The Town and Country Planning Act 1990 (as amended)

New bungalow

To The Rear Of 5 Nyetimber Close Bognor Regis

Decision: OBJECTION □

SITE PLAN 1 : 200

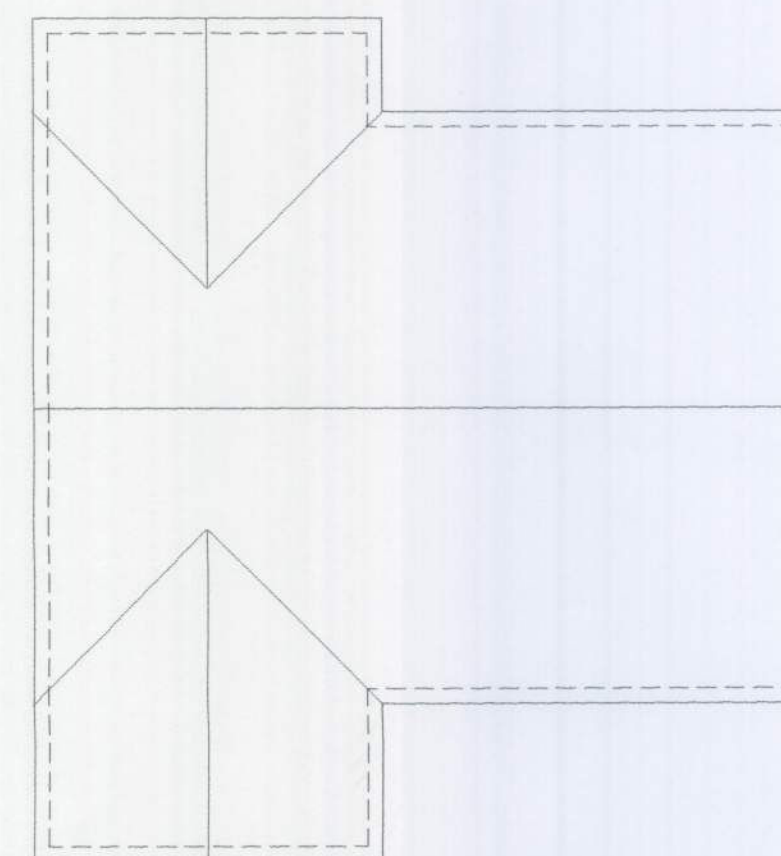
The access to the proposed bungalow, together with the hammerhead drive gives rise to a loss of some 250 square metres of garden area, and this combined with the building footprint removes in excess of 240 square metres of garden, replaced with impermeable and semi-impermeable surfaces thereby adding to increased risk of surface water flooding. □

The proposed vehicular access is not of sufficient width to provide ready access to emergency vehicles such as fire engines, a particular concern given the pine trees to side and rear of this and adjoining properties. □

Finally it was felt that the existing trees were at risk from this development. □
